**KIRKLEES METROPOLITAN COUNCIL
INVESTMENT & REGENERATION SERVICE**

Reference No: 2017/62/92965/E

Site Address: 6, Howard Place, Batley, WF17 6AB

Description: Erection of two storey side extension and erection of garage and store room to rear

(HOWARD PLACE STREET SCENE)
PROPOSED FRONT ELEVATION, SCALE 1:100

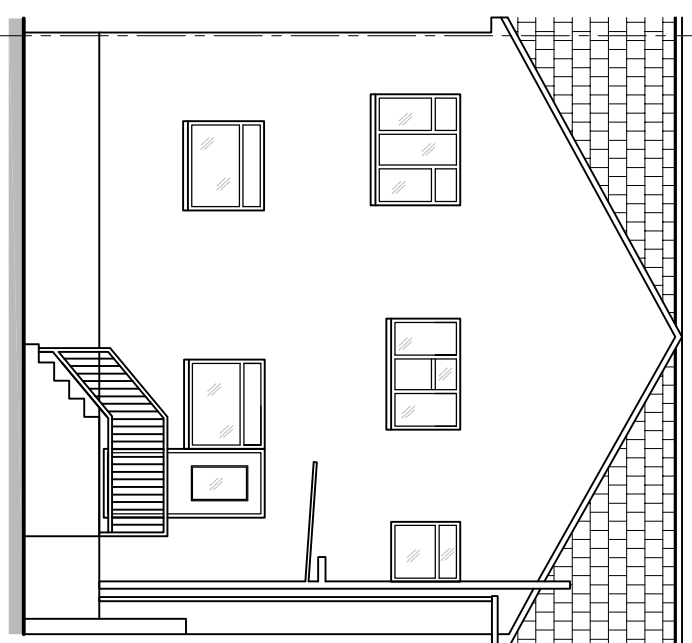
6. Notwithstanding the submitted details in drawing no PL-01(C), the development shall not be occupied until the window in the north east elevation of the two storey side extension hereby approved have been obscure glazed to a minimum grade 4. Notwithstanding the provisions of section 55(2)(a)(ii) of the Town and Country Planning Act 1990 and the Town and Country Planning (General Permitted Development) Order 2015 (or any order revoking or re-enacting that Act or Order with or without modification), the obscure glazing (to a minimum grade 4) shall thereafter be retained.

BLOCK PLAN (PROPOSED), 1:200

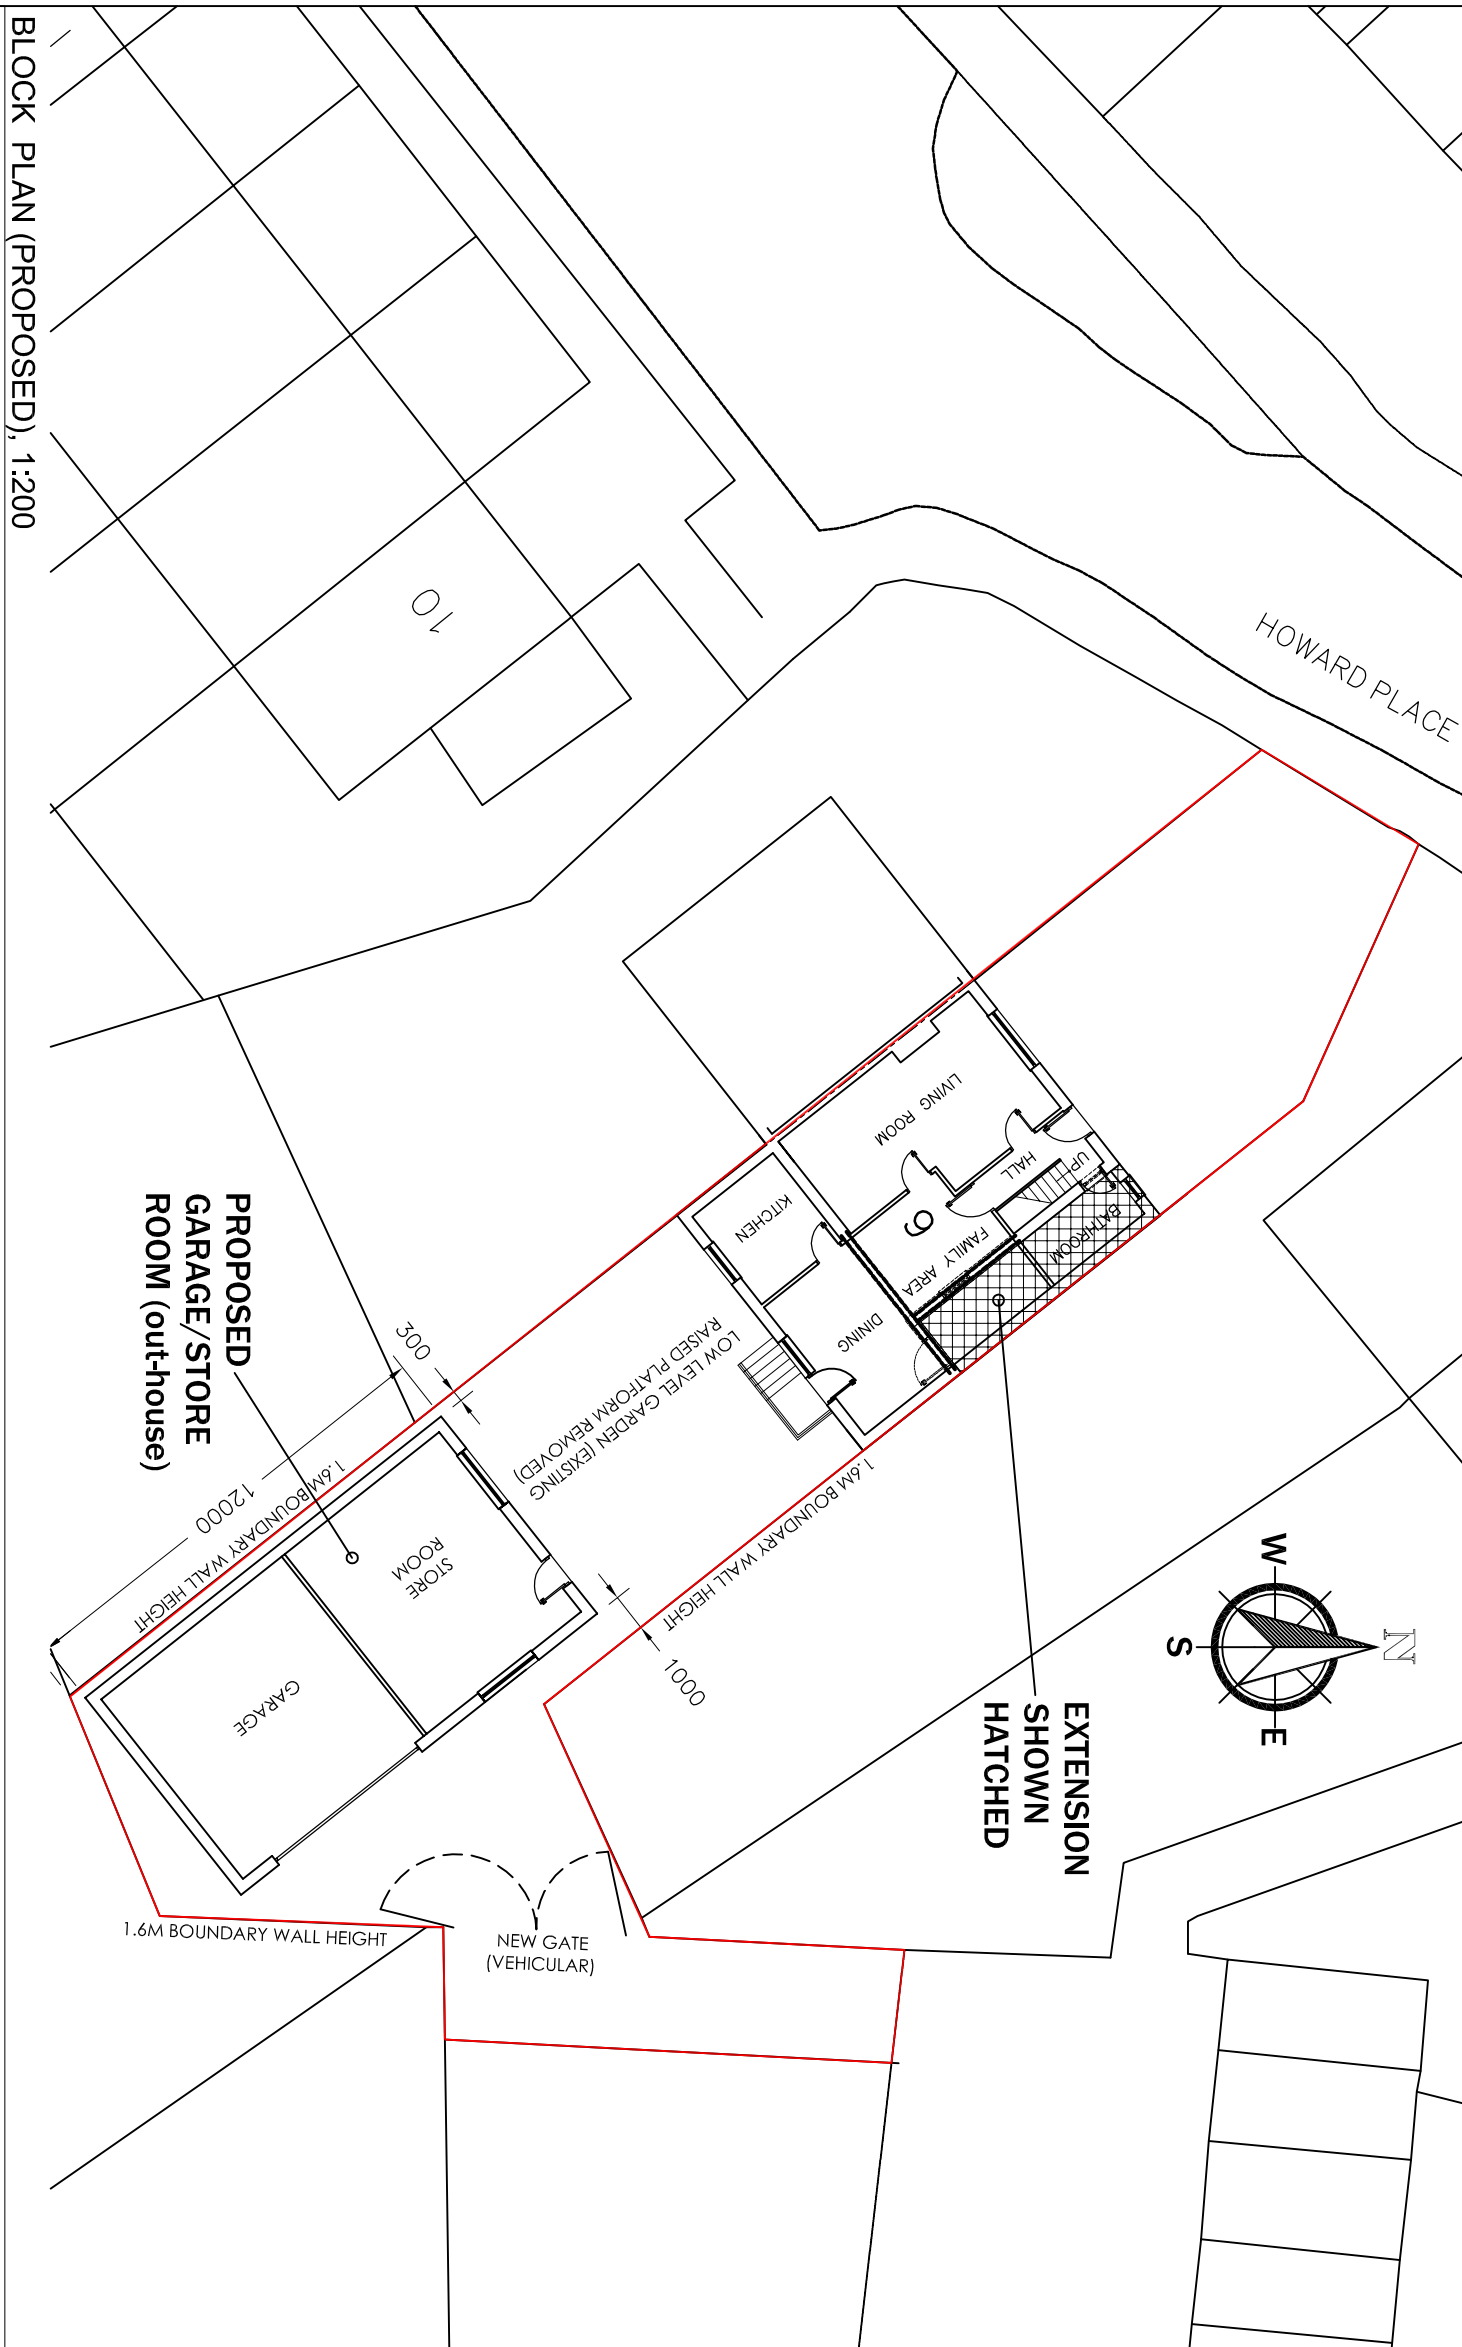
The red line boundary has been extended to include the unauthorised track adjoining the rear boundary of the application site. The depth of the outbuilding has also been reduced from 12 metres to 10 metres. These amendments have been illustrated on the revised drawing (*Ref: PL-01 REV.C*) received on 09/10/2017.

K.C. Highways Development Management – Red line boundary needs to be extended over verge and to edge of adopted highway i.e. Skipton Street. The minimum garage size shall be 6 metres long and 5 metres wide. A 4 bedroom house shall provide parking spaces sufficient for 3 vehicles.

The submitted group plan (Ref: PL-01 REV.C) indicates a red line boundary covering an existing unauthorised track to the rear of the application site across the verge under the ownership of Kirklees Council (notice was served during the course of the application). To regularise the existing track and in the interest of highway safety, a condition shall be added to require a hardened and drained surface to be laid in areas indicated for vehicle access.

4. The development shall not be brought into use until all areas indicated to be used for access and parking on the approved plan(s) have been laid out with a hardened and drained surface in accordance with the Communities and Local Government; and Environment Agency's 'Guidance on the permeable surfacing of front gardens (parking areas)' published 13th May 2009 (ISBN 9781409804864) as amended or any successor guidance; Notwithstanding the provisions of the Town and Country Planning (General Permitted Development) Order 2015 as amended (or any Order revoking or re-enacting that Order) this shall be so retained, free of obstructions and available for vehicle access.
